From: Holly Duncan
Sent: Monday, June 04, 2012 11:17 AM
To: Jeff Watson
Subject: RE: BL-12-00008 Whitaker

[BL-12-00008 Whitaker](#)

THE NORTHWEST QUARTER OF SECTION 34, TOWNSHIP 19 NORTH, RANGE 18 EAST, WILLAMETTE MERIDIAN BOUNDARY LINE ADJUSTMENT

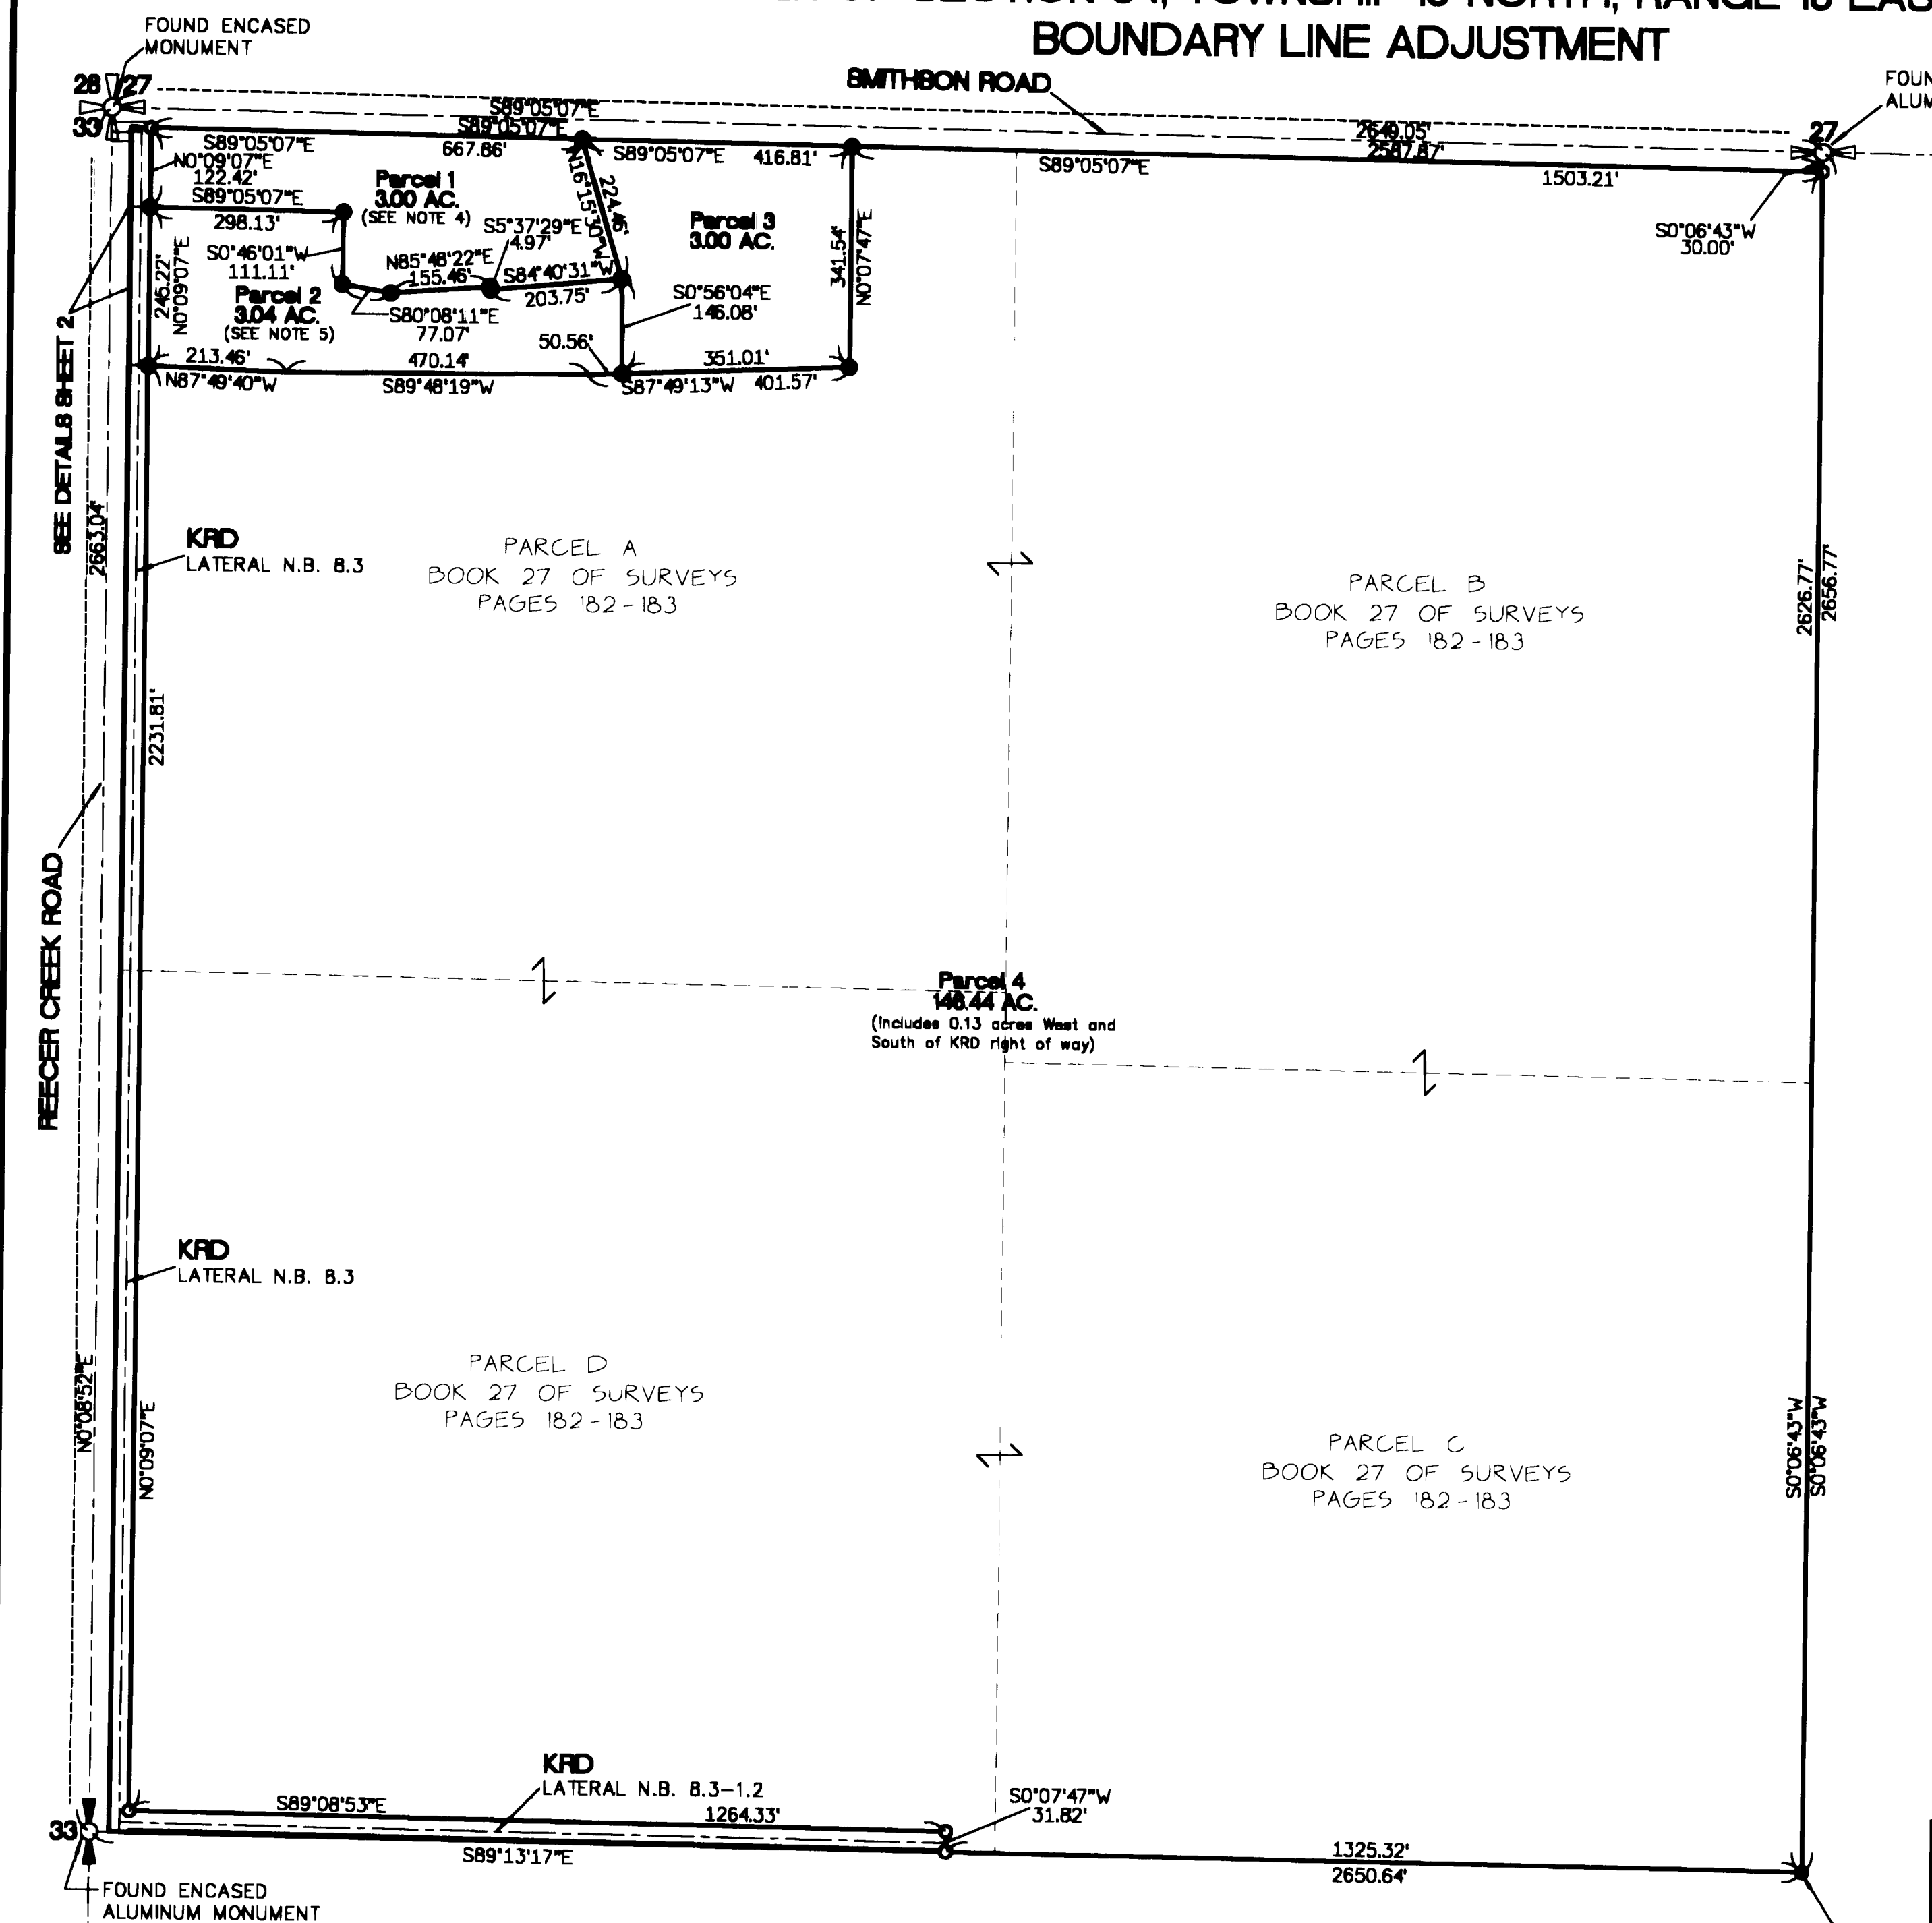
My concerns with this one are the locations of the wells and drainfields. All wells must be 50 feet from the proposed property lines and drainfields must be at least 5 feet from property lines.
